The Secretary  
NSW Department of Planning, Industry and Environment

4 November 2020

I refer to the Department's below email of 2 November 2020 regarding the notice of exhibition of the Environmental Impact Statement (EIS) for State Significant Development SSD-10472 Expansion of the Museums Discovery Centre at 2 Green Road, Castle Hill (LOT 102 DP 1130271). Submissions need to be made to the Department by 1 December 2020.

DRAWING
LANDSCAPE PLAN

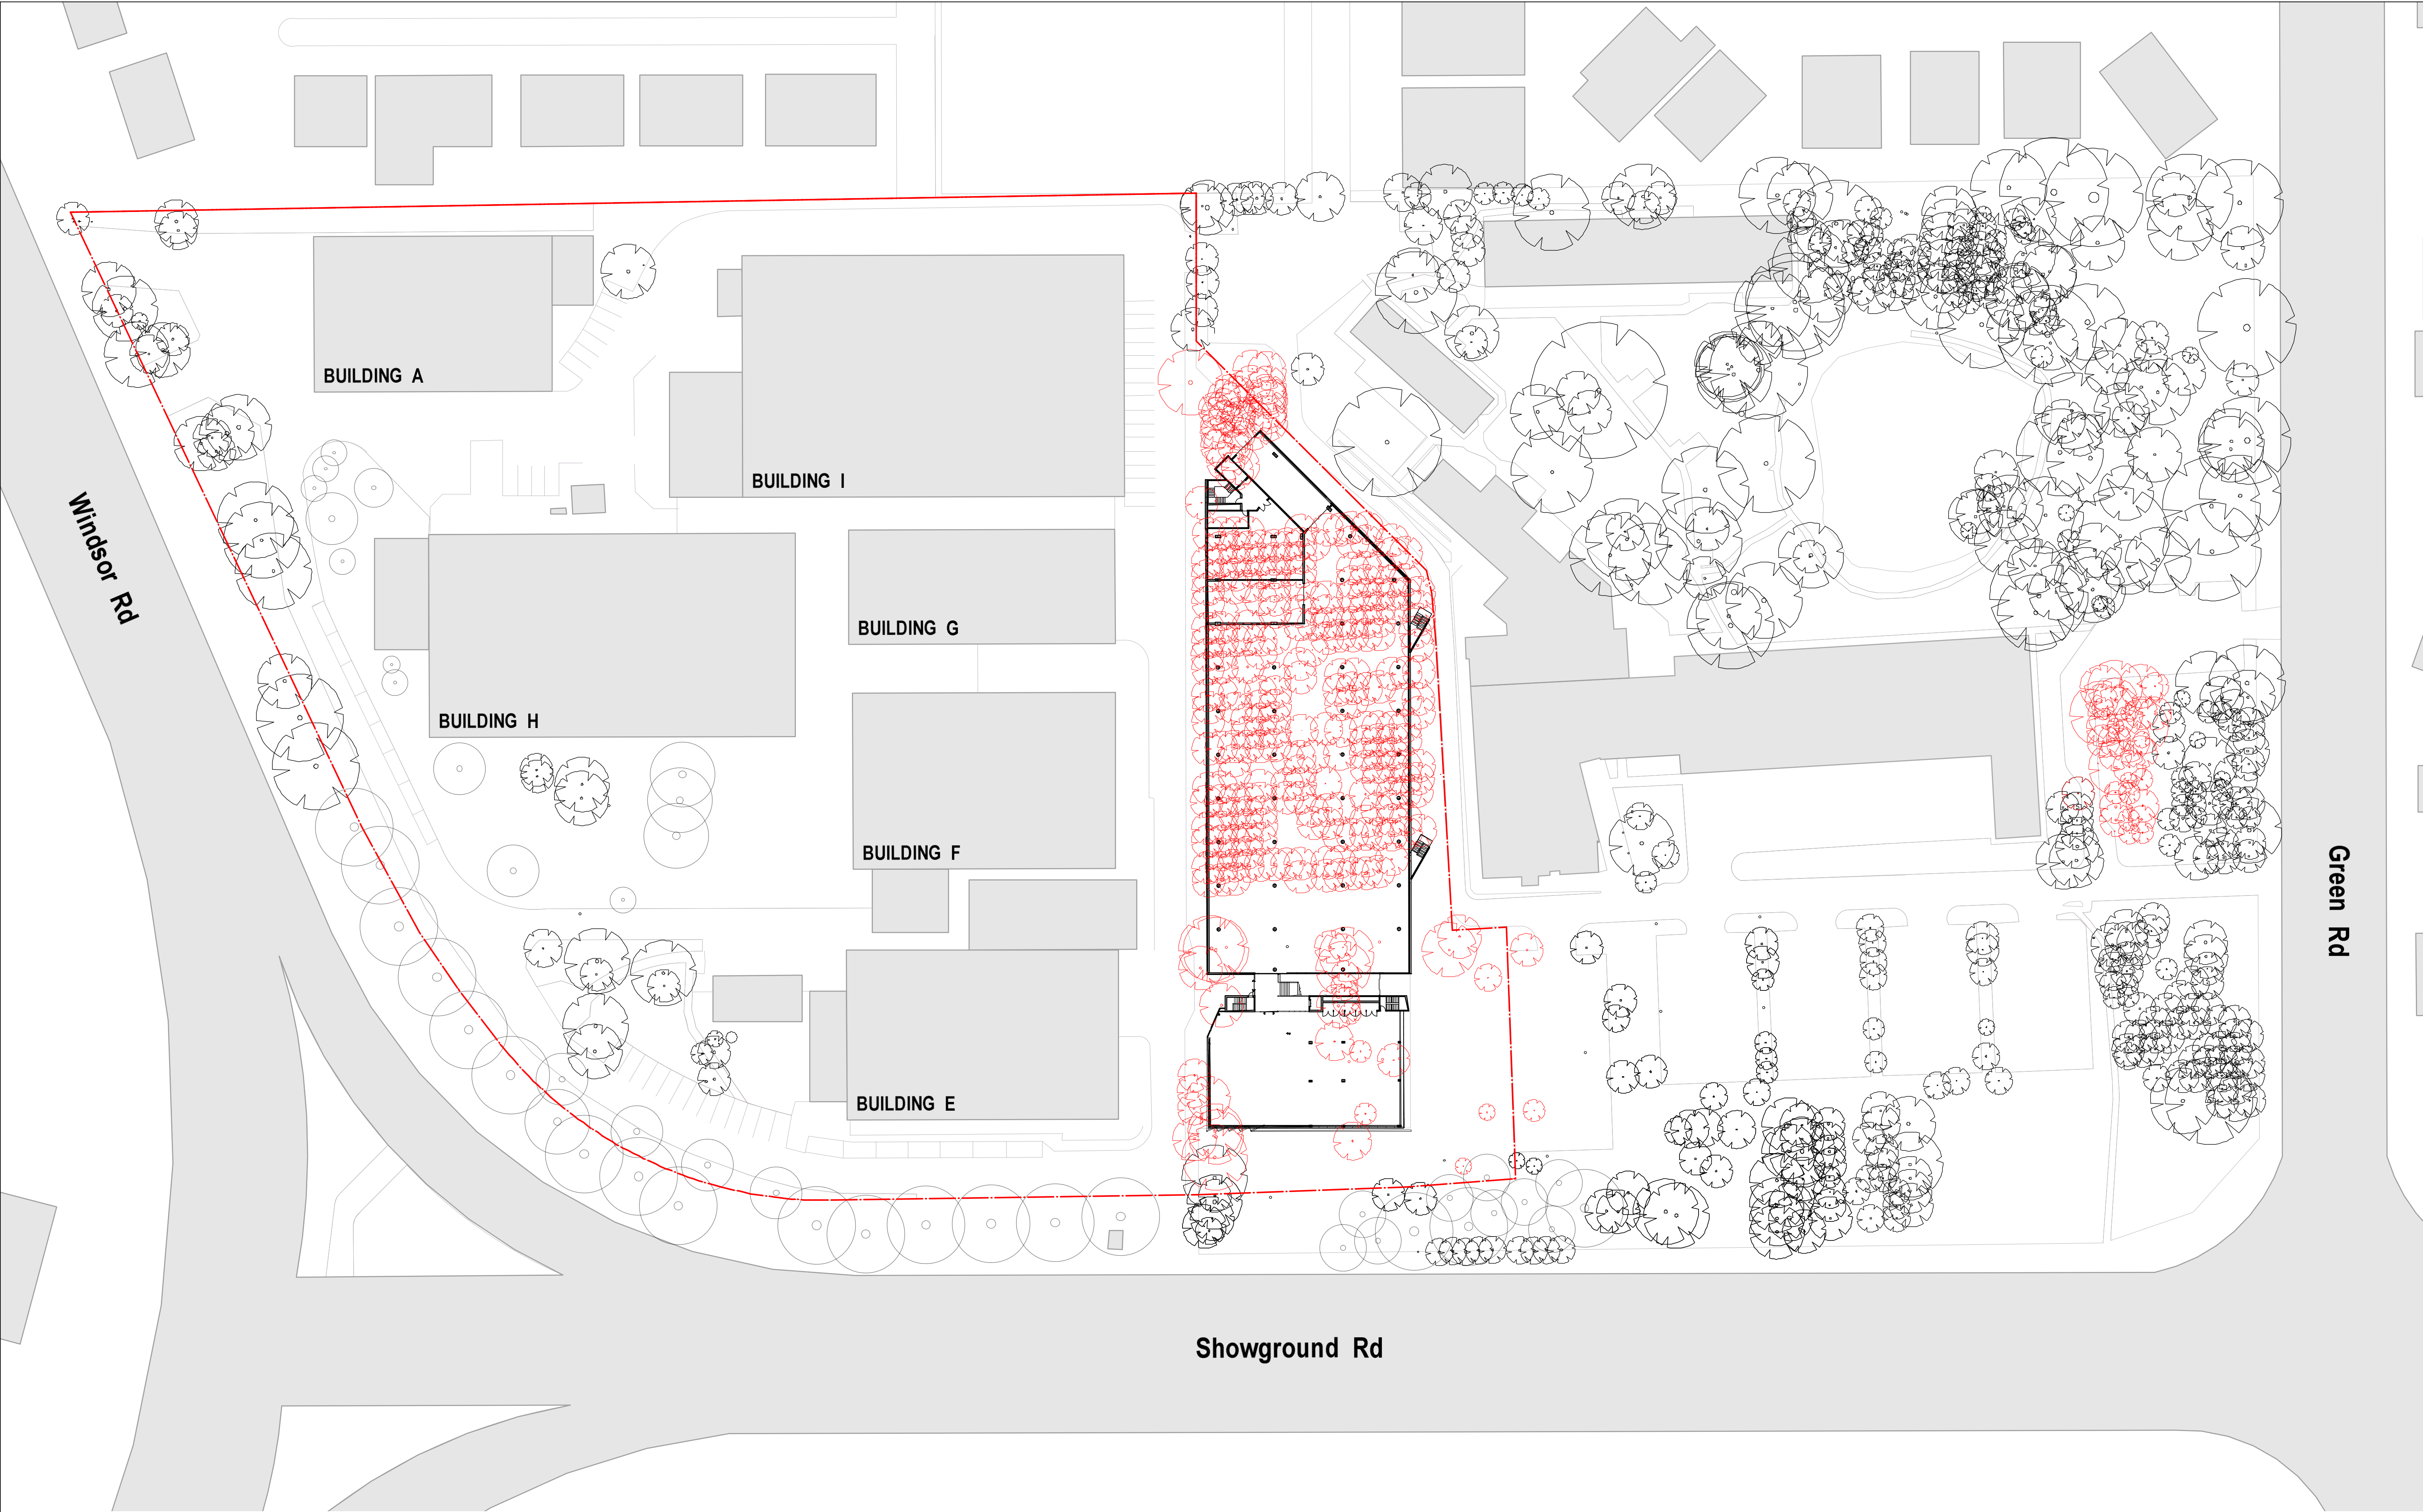
Endeavour Energy has noted that whilst Appendix G 'Landscape Plans' of the EIS does not show the location of the proposed padmount substation, Appendix F 'Landscape Report' includes the following:

It is not readily apparent how the proposed landscape proposals will not conflict with the existing and proposed electricity infrastructure on the site. The landscape designer will need to reconsider if the proposed plantings achieve the requirements outlined in Endeavour Energy's previous submission in regard to the proximity to the overhead power lines and underground cables. For the padmount substation, no vegetation is to be planted within the substation easement. Screening vegetation should be planted a minimum distance of 800mm plus half of the mature canopy width from the substation and have shallow / non-invasive roots. This is to avoid trees growing over the easement as falling branches may damage the cubicle and the electricity infrastructure as do tree roots. All vegetation is to be maintained in such a manner that it will allow unrestricted access by electrical workers to the substation easement all times.
